DOOLEY'S LIDCOMBE CATHOLIC CLUB - SSD 7603

COMMENTS FROM CUMBERLAND COUNCIL

Thank you for the opportunity to comment on the Concept Proposal for Tourist Related Purposes and Detailed Proposal for early works at Dooleys Lidcombe Catholic Club, Lidcombe, SSD 7603.

PARKING SCHEDULE
Disabled Carpark Bay
14
Standard Carpark Bay
596
Grand total: 610

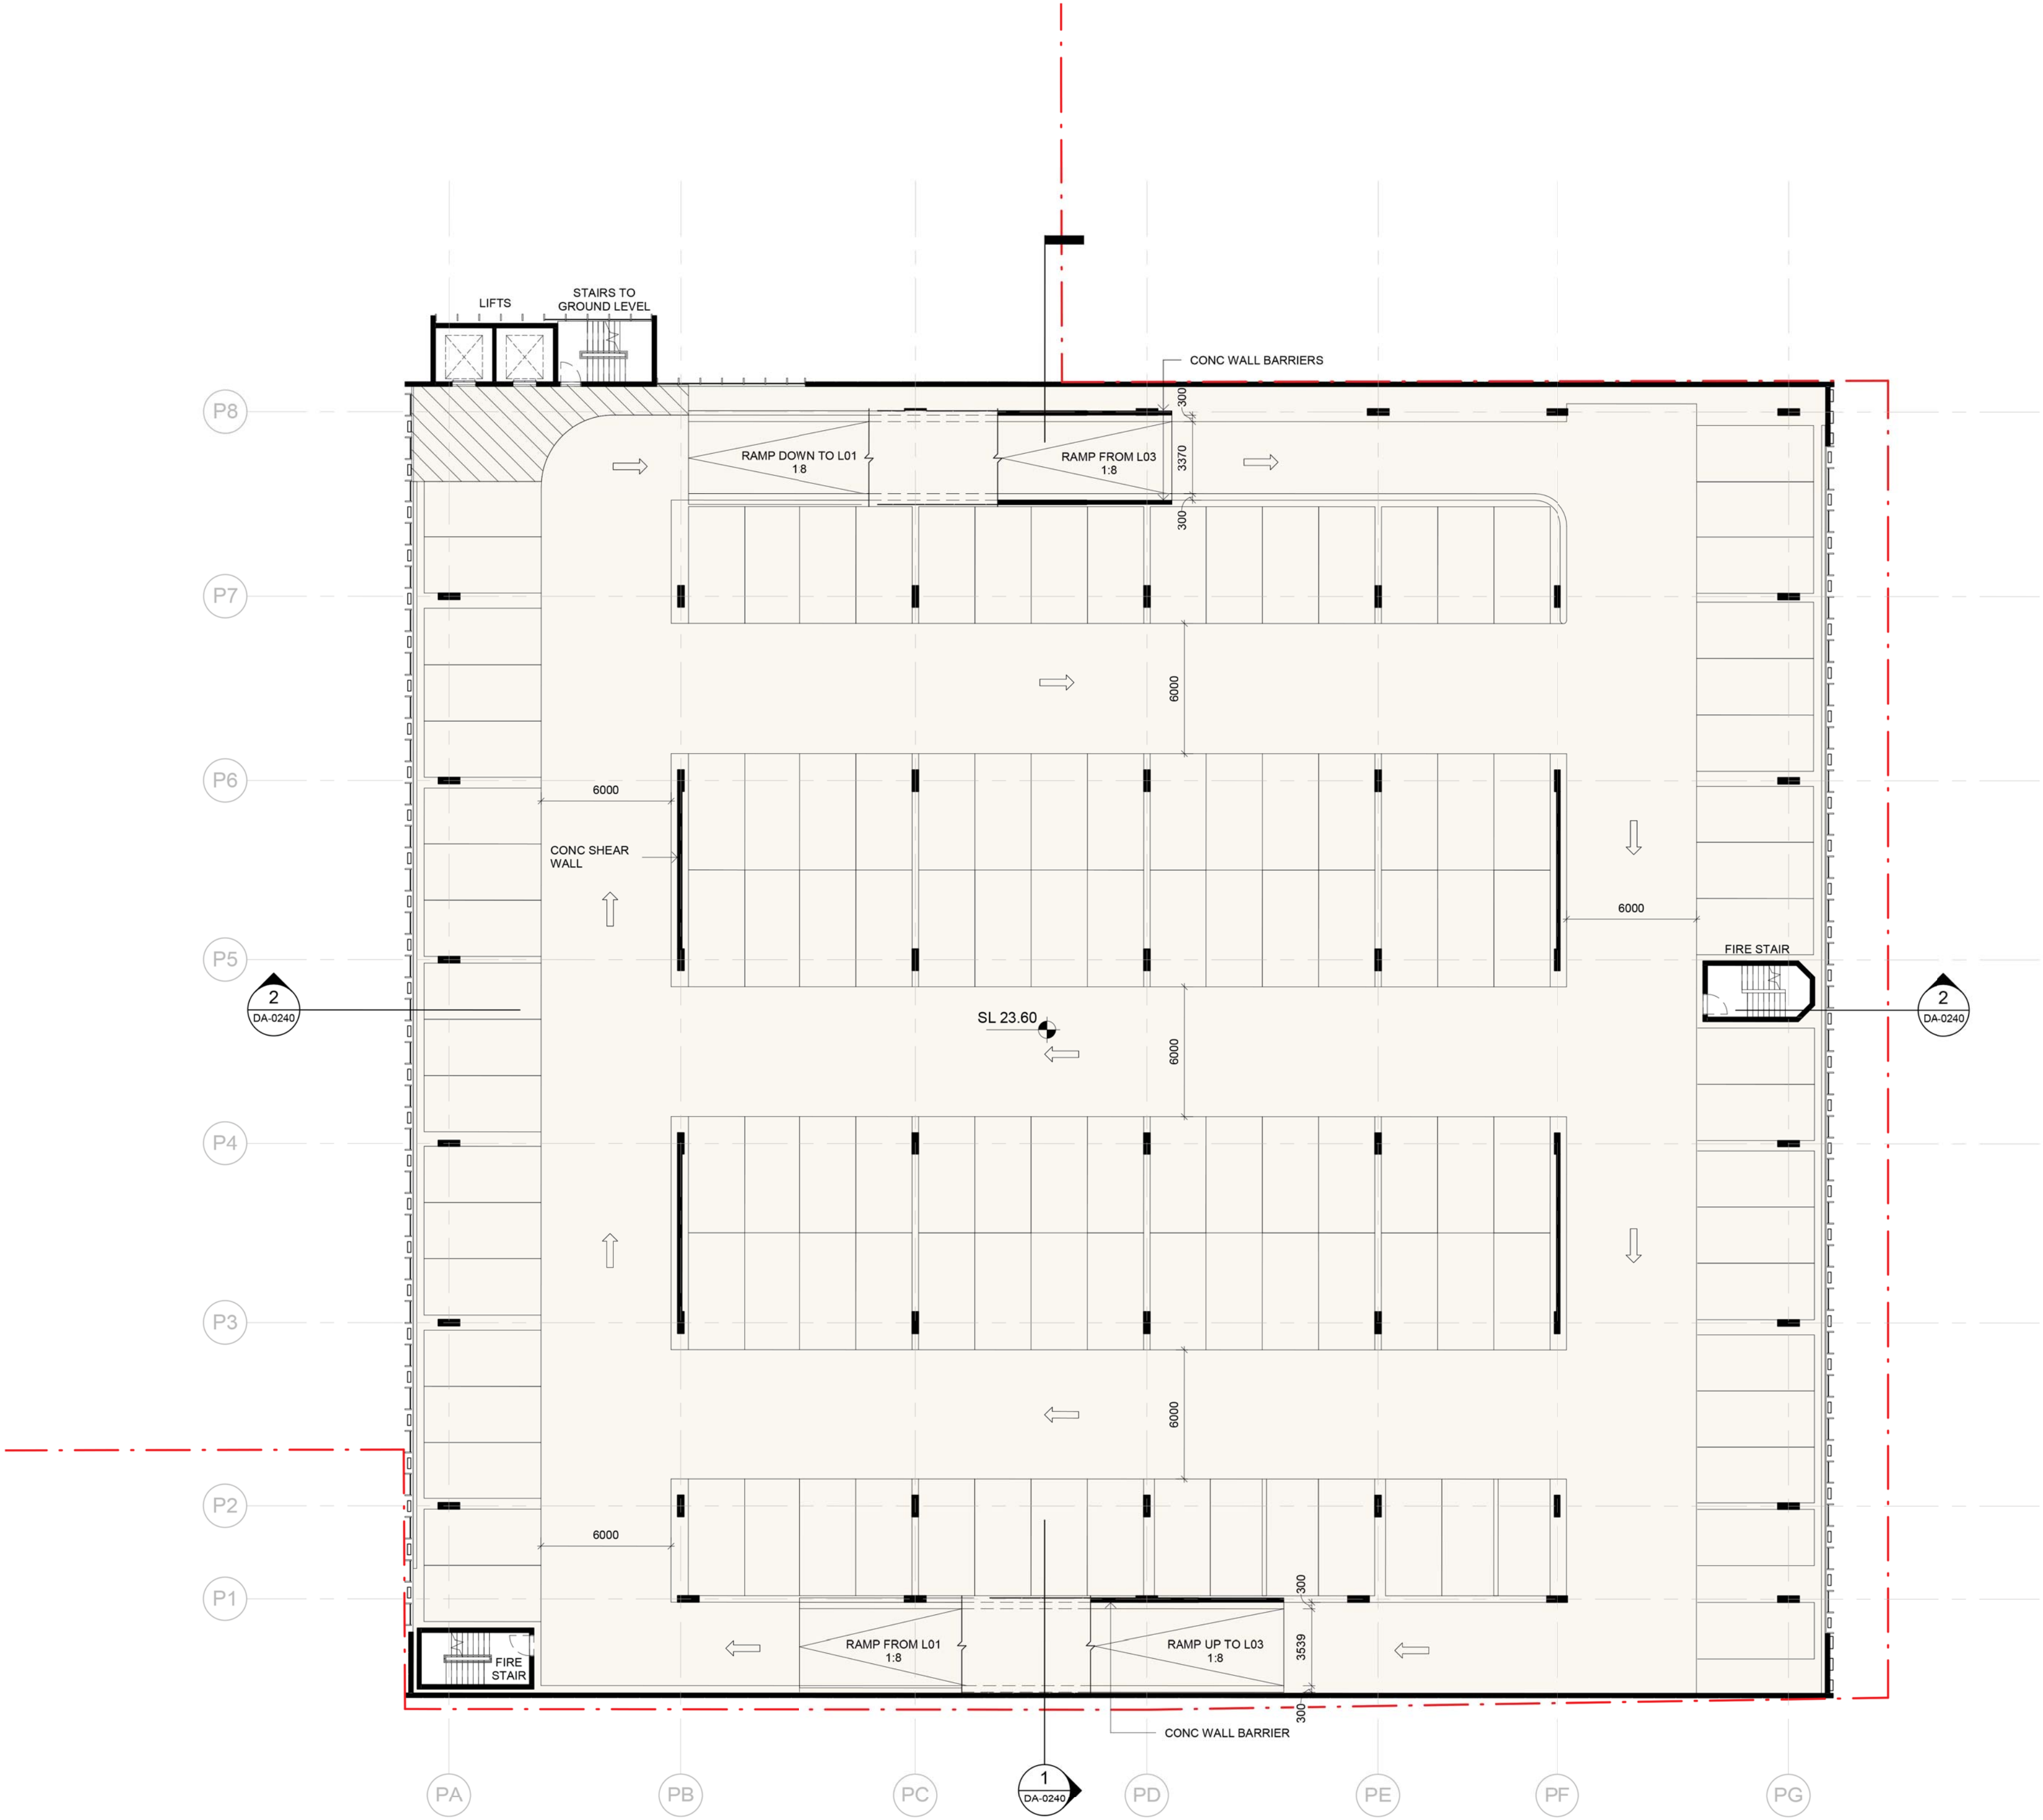
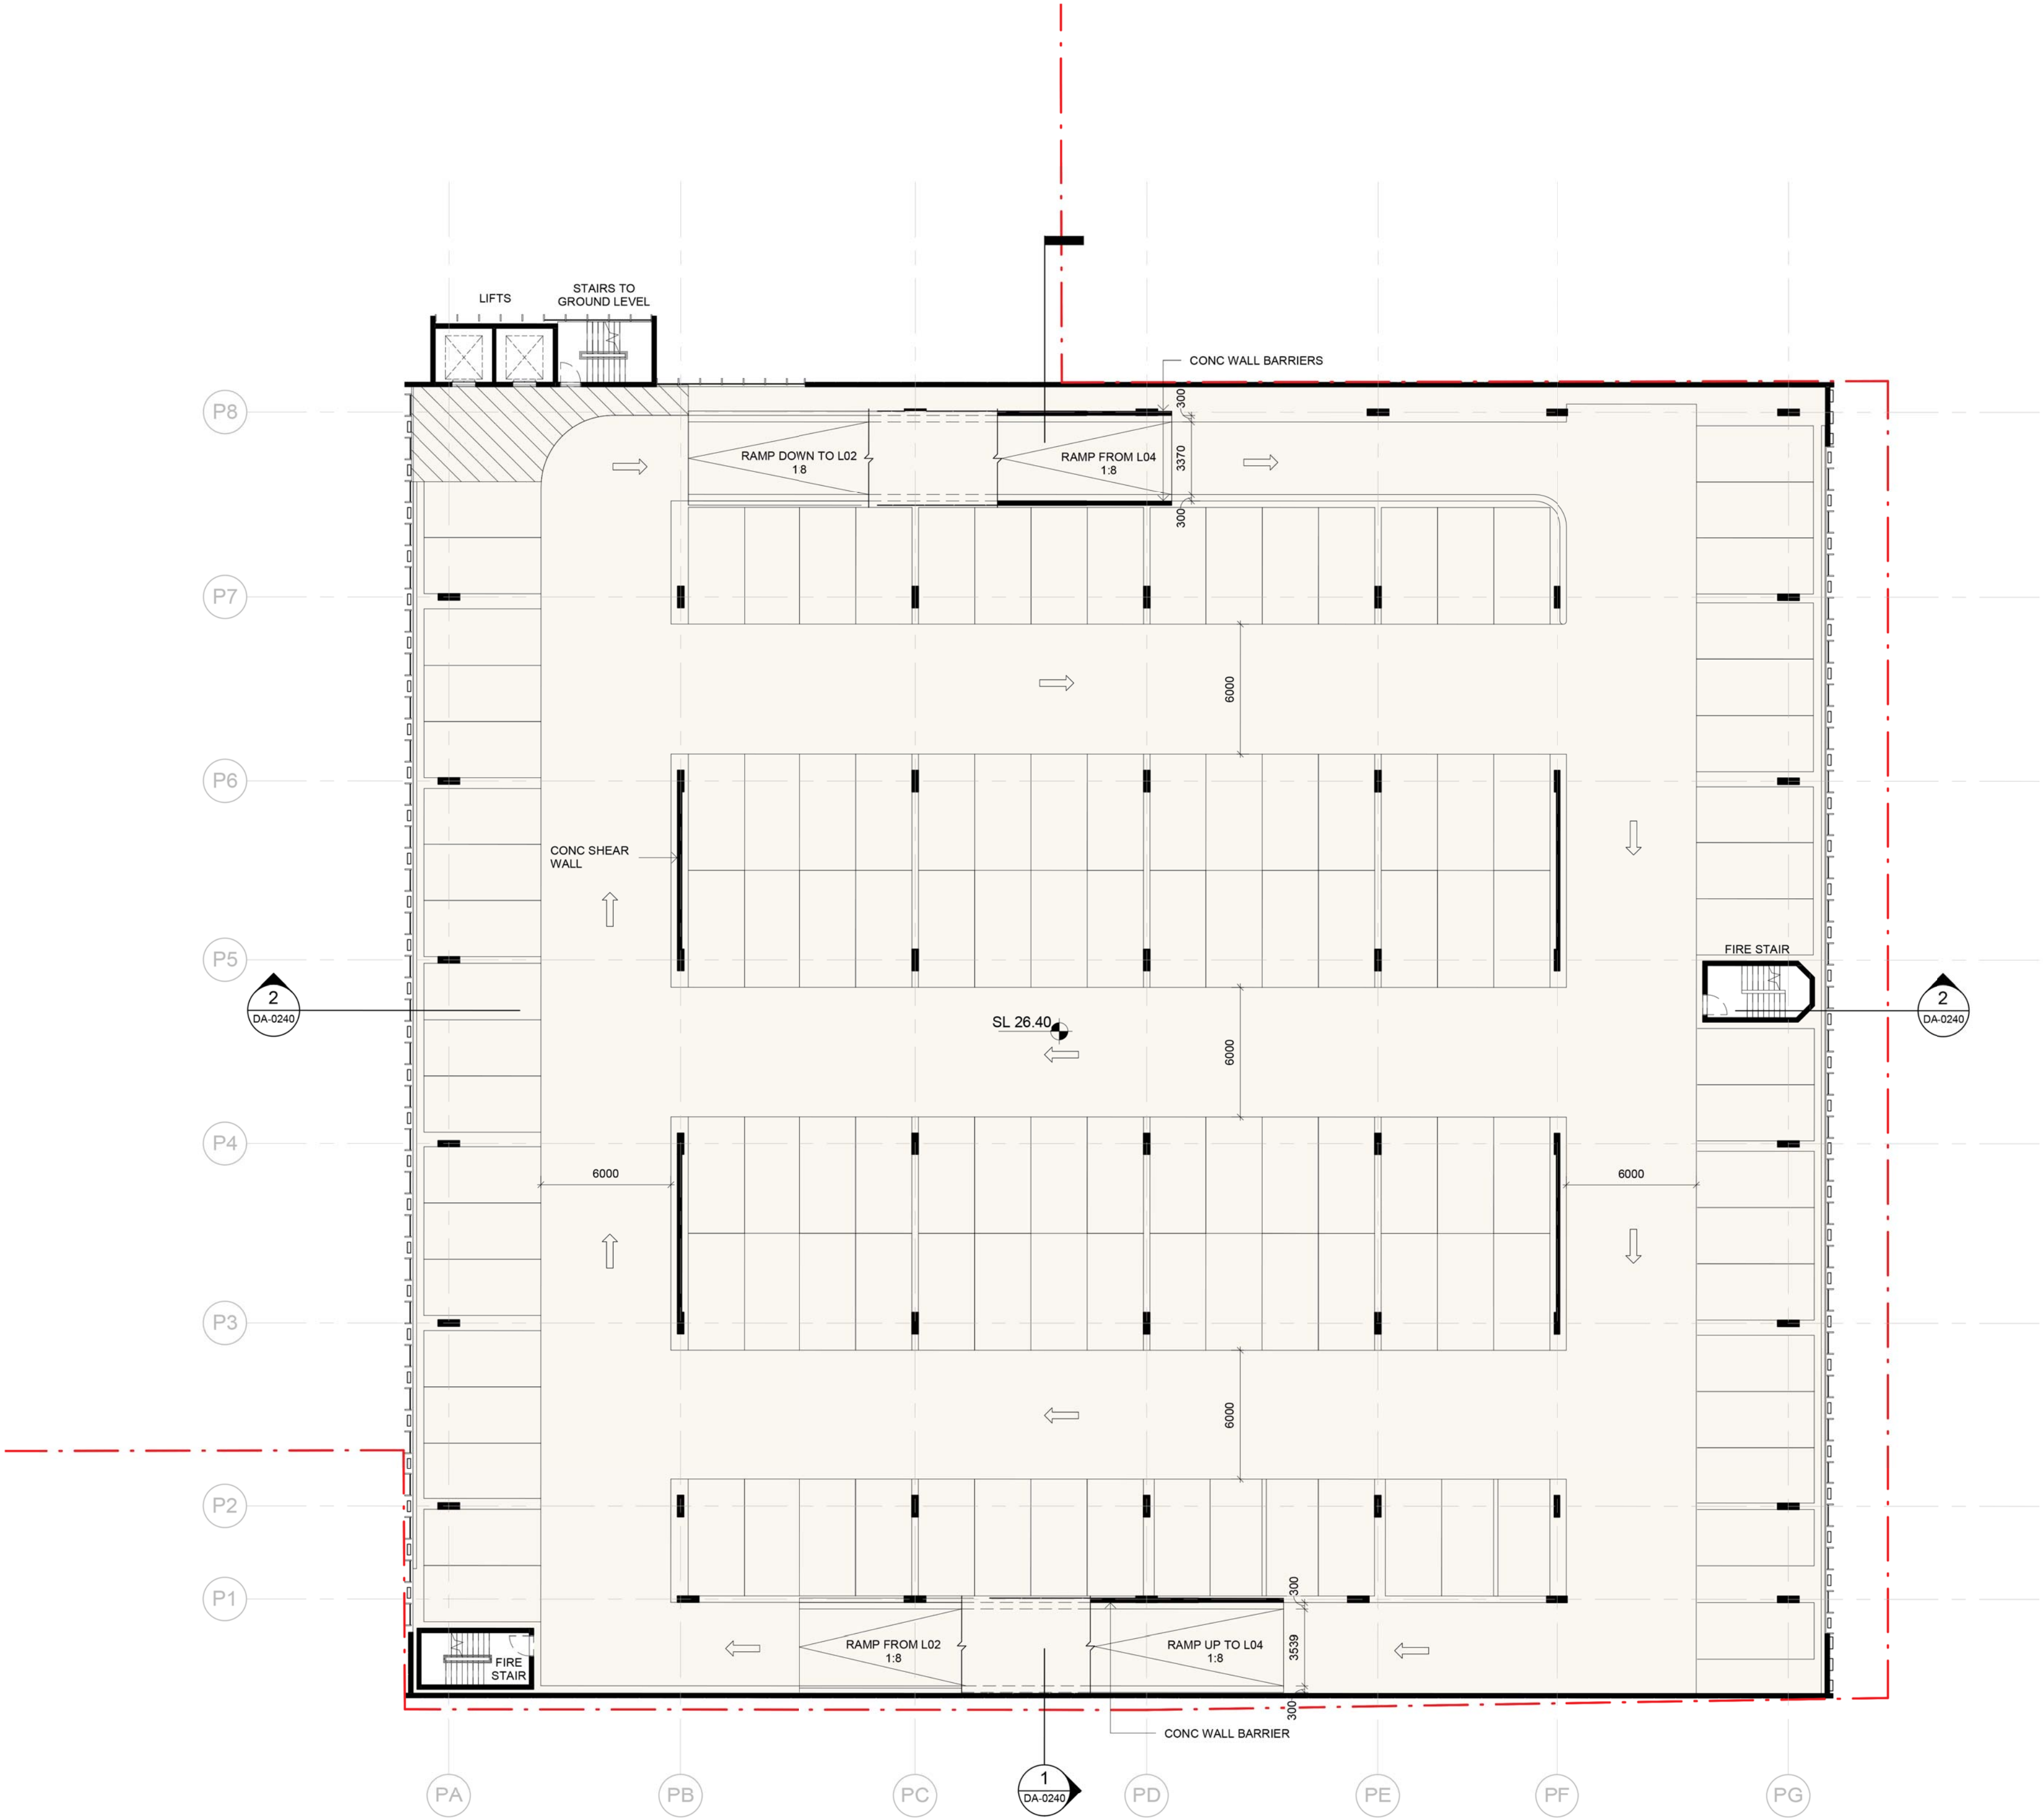
The requirements of *Built Form, Urban Design and Public Domain – Stage 1* of the SEARS do not appear to have been addressed in relation to the multi-storey car park. Discussion of alternatives to the above ground car park or provision for adapting the building for future uses, and activating the ground floor, could not be found in the documentation provided.

Council strongly recommends that there be adequate basement parking to address the requirements of the entire concept plan, without relying on above ground car parking. Should the Department nevertheless accept the concept of a permanent above ground car park in the future commercial area of the town centre, it is requested that:

- a. The structure be sleeved in active uses along Board St to support a vibrant active Lidcombe centre, eg small professional offices
- b. That some of the parking within the structure be provided at basement level

- c. That the building be substantially setback from Ann St, with deep soil landscaping including trees in the frontage to the site (eg 4-6m)
- d. That there be a substantial landscaped setback to the isolated sites:
